Our Case Number: ABP-314724-22

Re: Railway (Metrolink - Estuary to Charlemont via Dublin Airport) Order [2022]
Metrolink. Estuary through Swords, Dublin Airport, Ballymun, Glasnevin and City Centre to
Charlemont, Co. Dublin

Ref: 314724

For: Railway (Metrolink - Estuary to Charlemont via Dublin Airport) Order [2022]

TARA STATION

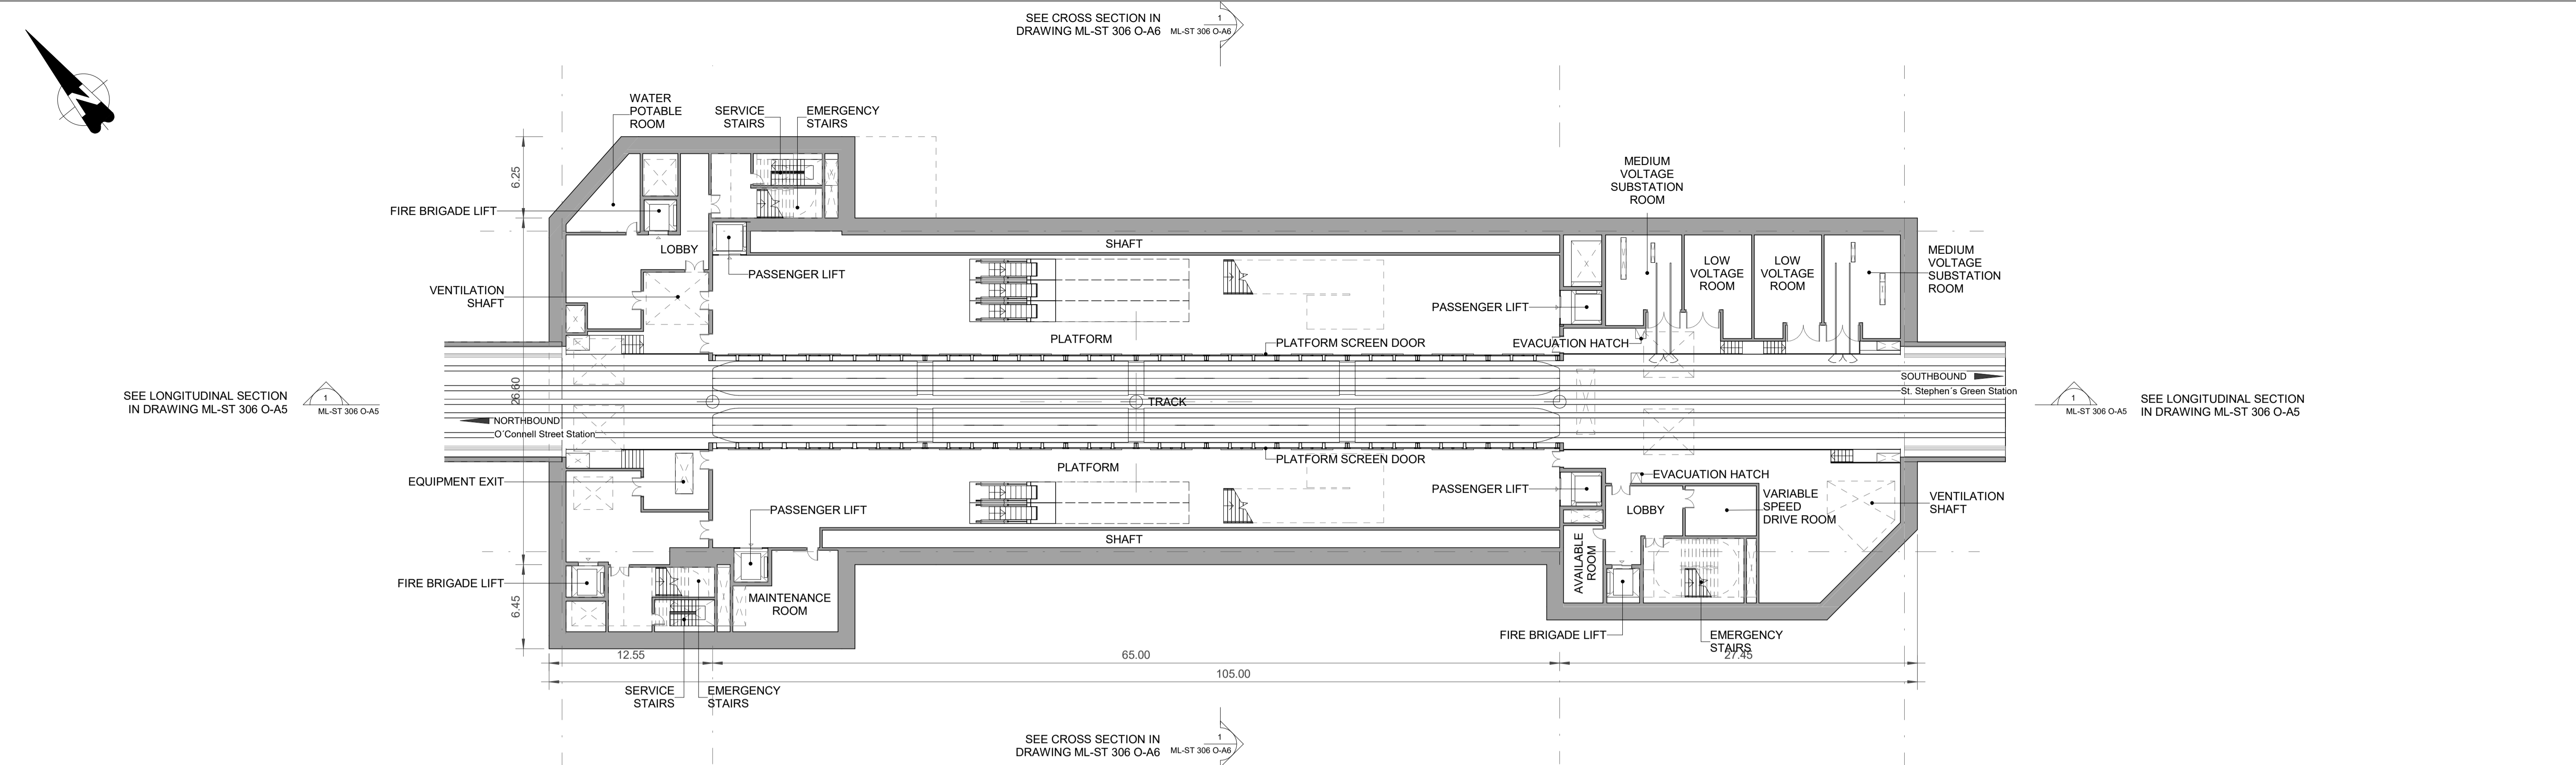
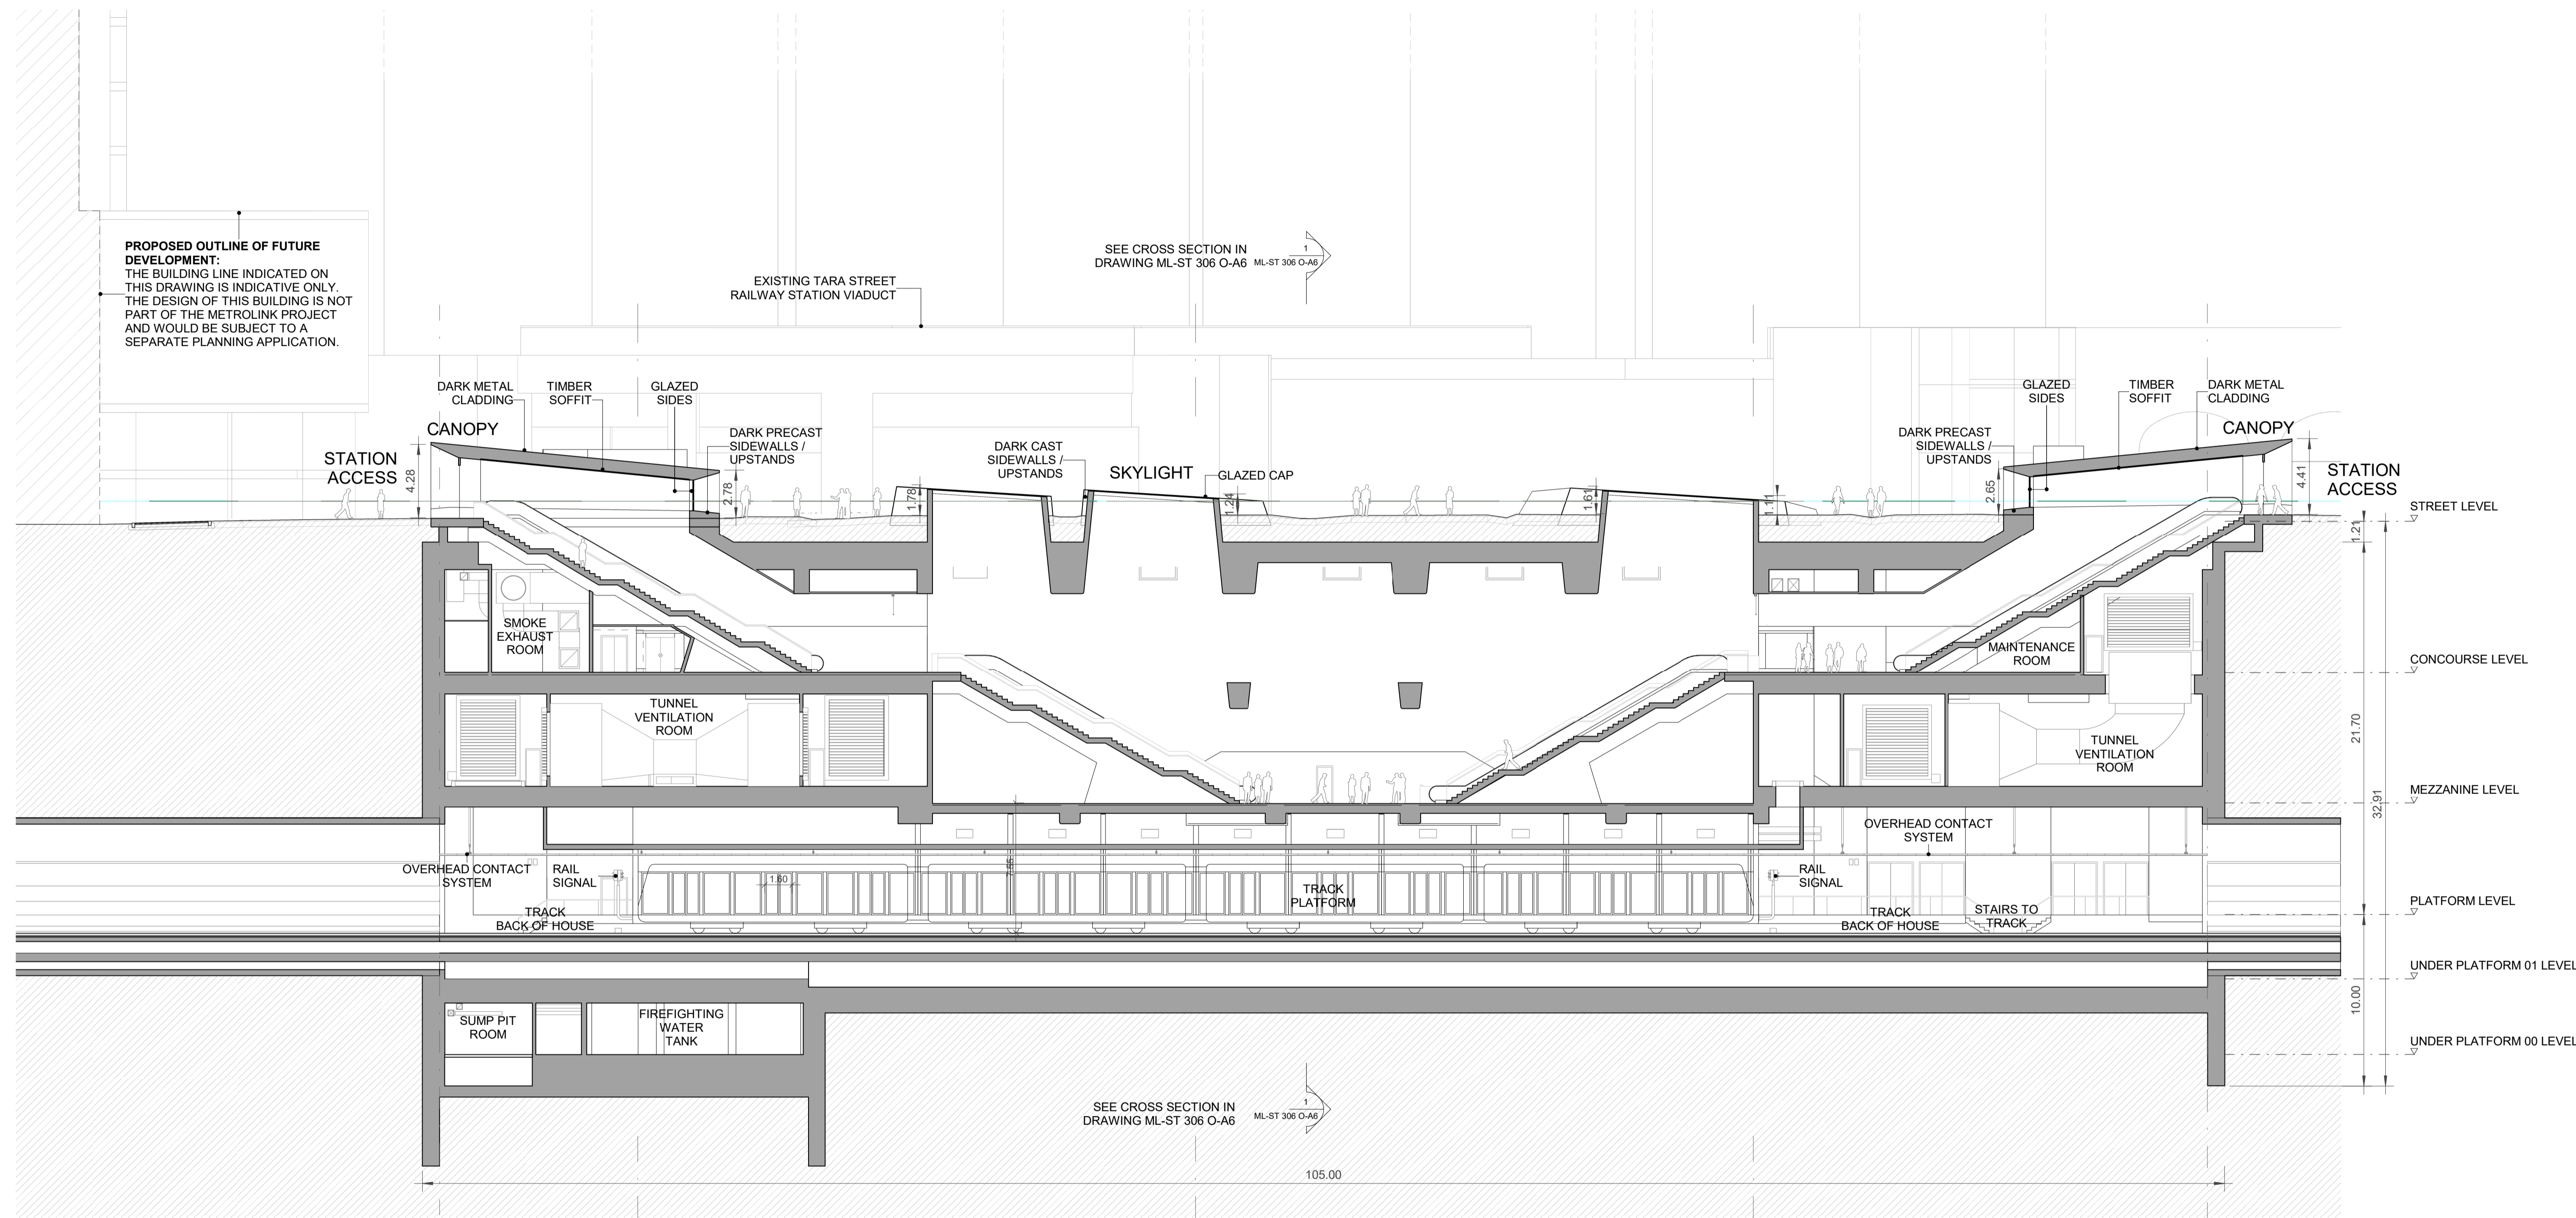
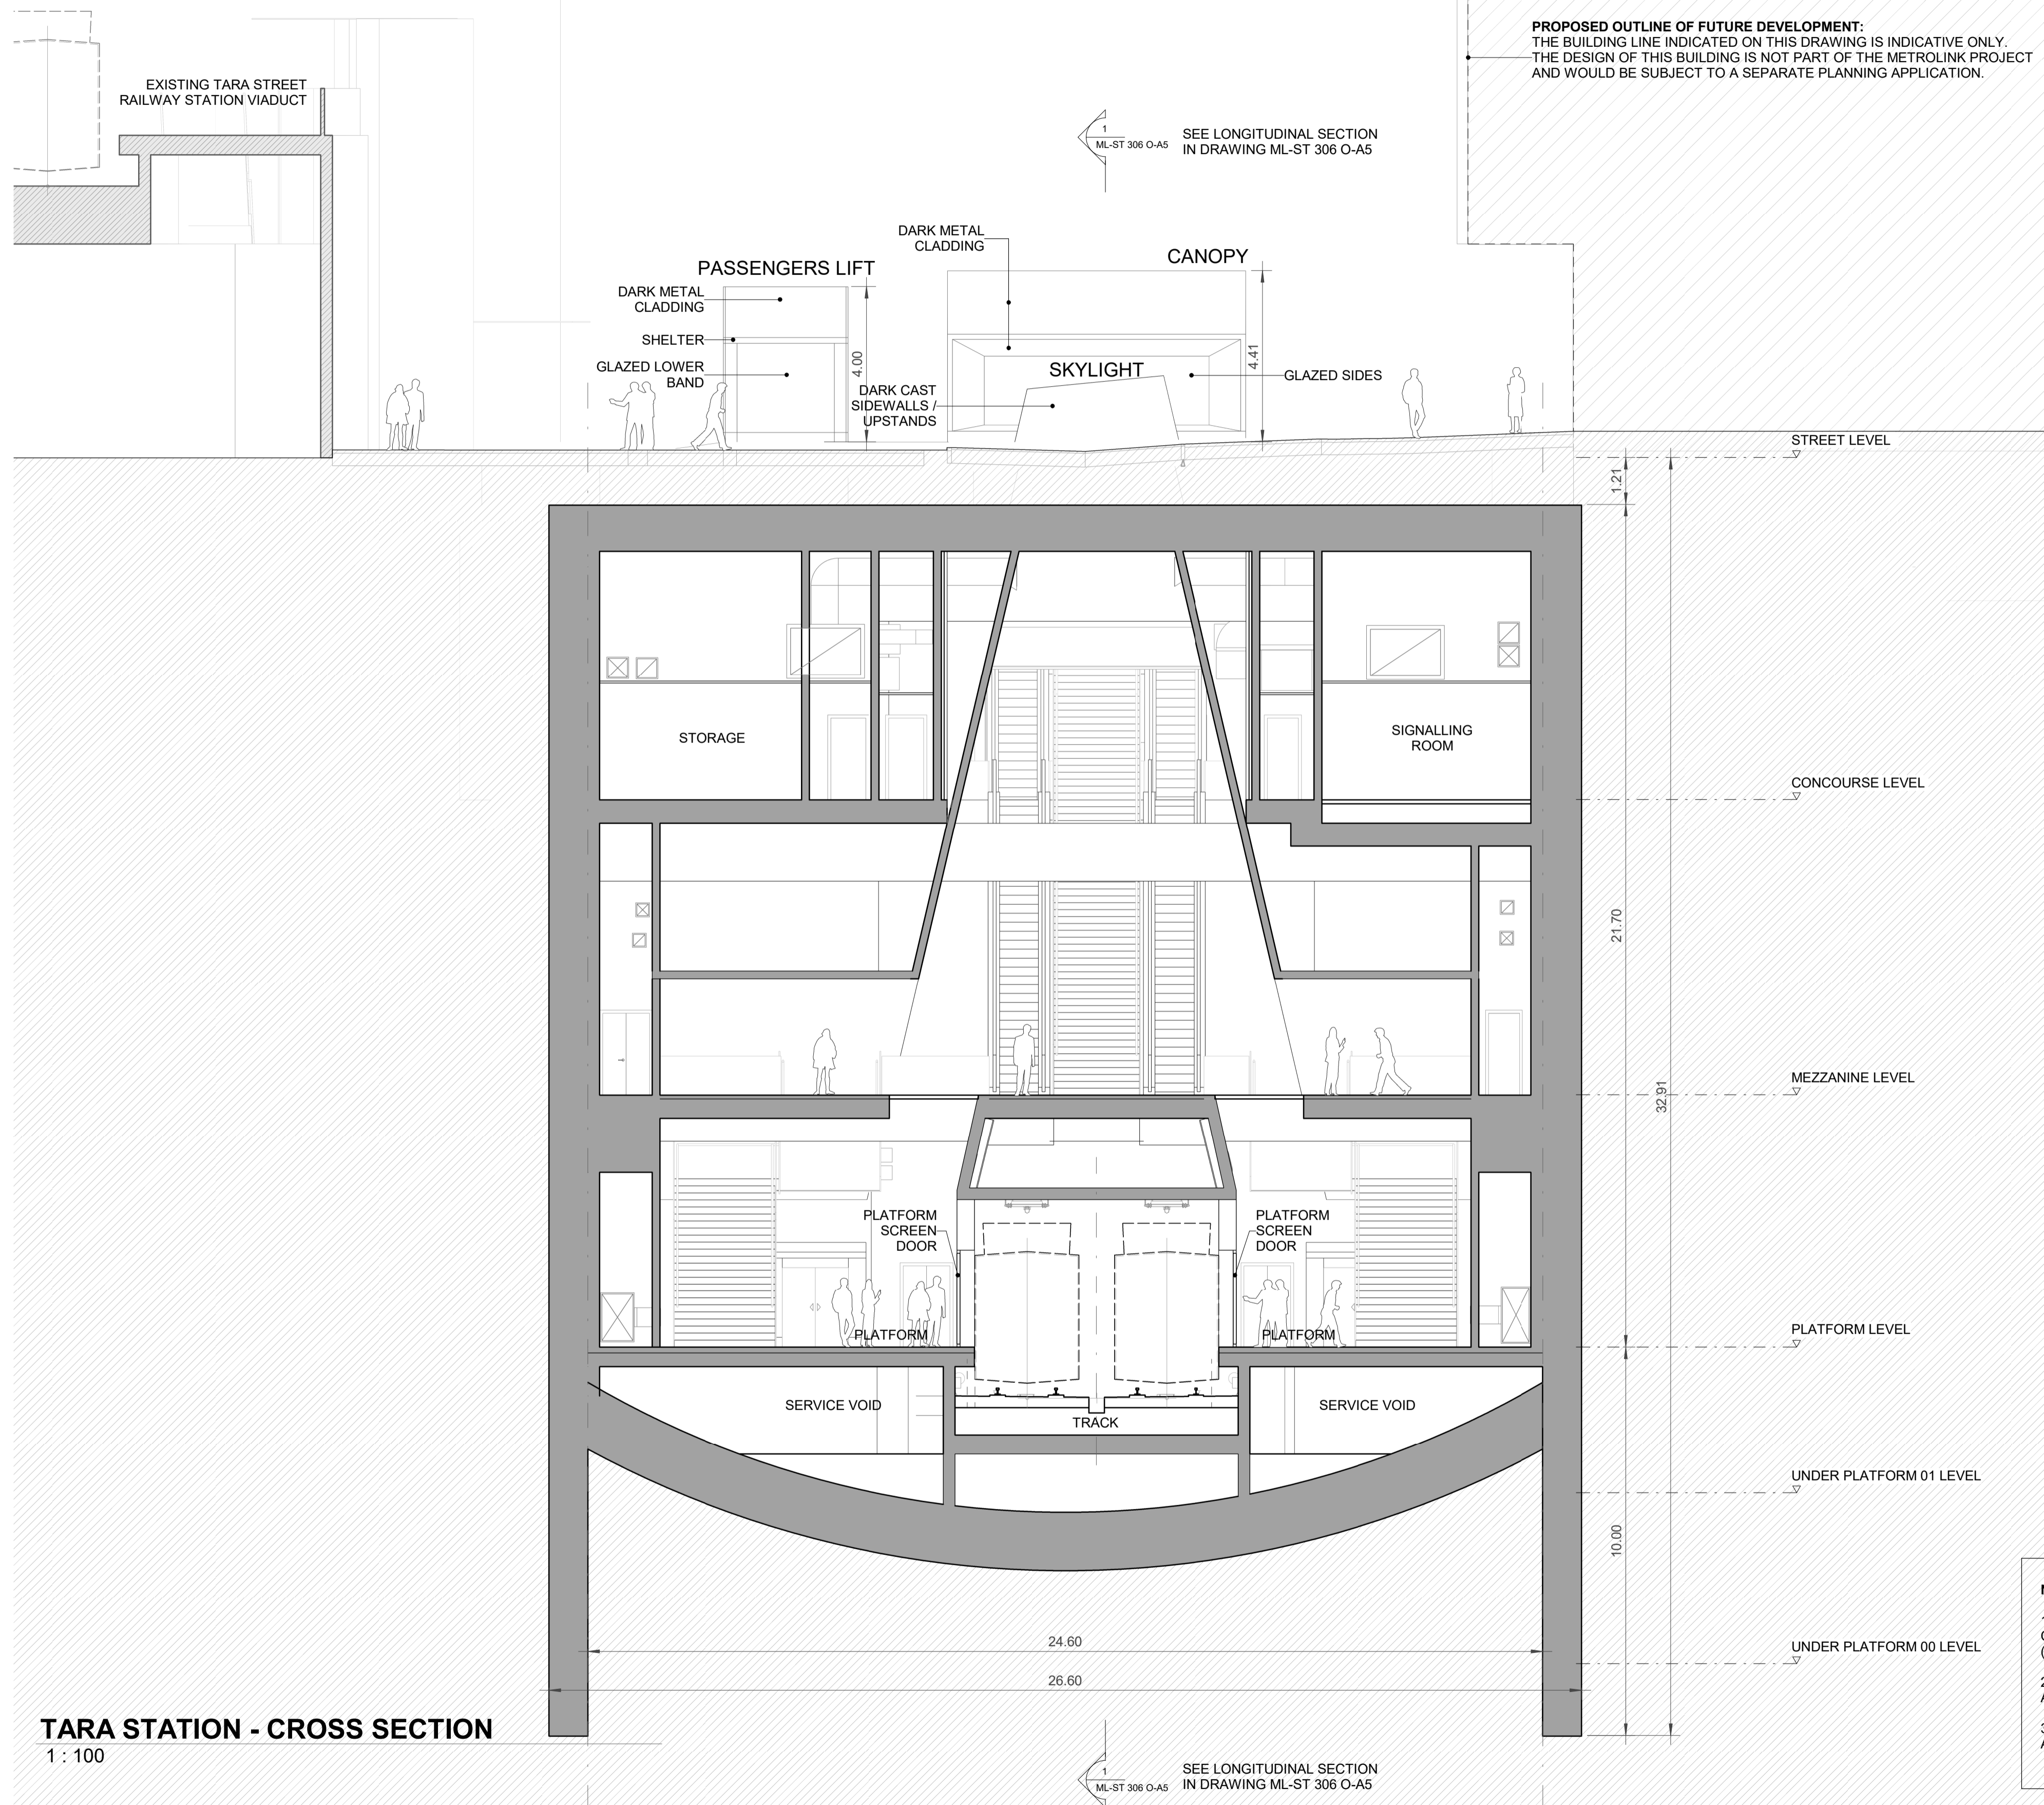
Based on the Metrolink Oral Hearing Documents, we will this submission on our concern that the selected option for the Tara Station, its selected site, and 'cut and cover' construction methodology will lead to the unnecessary loss of vital community infrastructure, and also be more expensive to the public purse.

Although the MetroLink project team explained the rationale behind the selection process behind the preferred site selection and 'cut and cover' construction method of the current scheme for the proposed MetroLink Tara Station at the Oral Hearing (please refer to Oral Hearing Documents for Second Round of Day 17 Book 1 of 1/ Tara Station Locations considered), in our submission to the hearing, An Taisce questioned CIE's decision making process, when this option would exact a substantially higher human cost, when compared with the next preferred OPTION 4 'with its excavated, mined structural construction method' on the same site', whereby the College Gate apartment building and leisure centre could be retained for up to approximately 60 million euros less.

Although the projected construction cost (listed in the Vol 5 App A7.2 - MetroLink RO) of the current station design(€139.9 Million excluding risk), is €21.8 Million cheaper than that of OPTION 4, which is projected to be €161.7M (also excluding risk but includes a ground issues allowance). However, these costs do not allow for relocation costs of the Markievicz Leisure Centre , which is currently projected to cost up to €48 million, according to a press release by DCC on 3/4/23. While estimated compulsory purchase compensation costs due to the owners of the 70 College Gate Apartments would add approximately €35 million, to the MetroLink budget, based on an average value (€450k) of current valuations of €450k-€550k per unit, as notified to the MetroLink Oral Hearing by Townsend Apartment Management that, With these figures added in, Therefore estimated final costs would be up to €222.9m for the current Tara Station design verses €161.7m for Option 4, which equates to 60 million euros difference, in favour of OPTION 4.

Option 4 involves mining a cavern below College Gate buildings, which carries more safety risks during its construction and is more expensive. While Option 4 would retain the College Gate Building there would be significant disturbance to residents, because of the shaft construction directly adjacent to the building (taken from RO EISR Vol. 5 – Appendix A7.2)

An Taisce then asserted that that while 'Project Risks and Constraints' raised by the applicant for OPTION 4, listed in Multi-Criteria Analysis, and those listed elsewhere in the applicant's Railway Order, were used to rule out the 'excavated, mined' construction method similar 'Project Risks and Constraints' have been successfully mitigated by numerous engineers and design teams on many other underground metro projects around the world, where similar construction techniques have been successfully utilised, to construct underground railway stations below occupied buildings, and therefore we would assert, that the applicant could also mitigate the same Risks and Constraints listed, if alternative construction strategies, were recommended, which would retain the College Gate Complex'.

And given that numerous metro stations have been successfully constructed through tunnelling underoccupied and inhabited structures, similar to the College Gate and Markievicz complex, with all risks and constraints being mitigated, we would recommend that the planning inspector and An Bord Pleanála request the applicant to seek to retain the College Gate complex, through the utilisation of alternative construction methodologies, such as that outlined in Option 4 of the Multi-Criteria Analysis, in Volume 5 – Appendix A7.2 Tara Street Station Report in the EIA of the Railway Order.
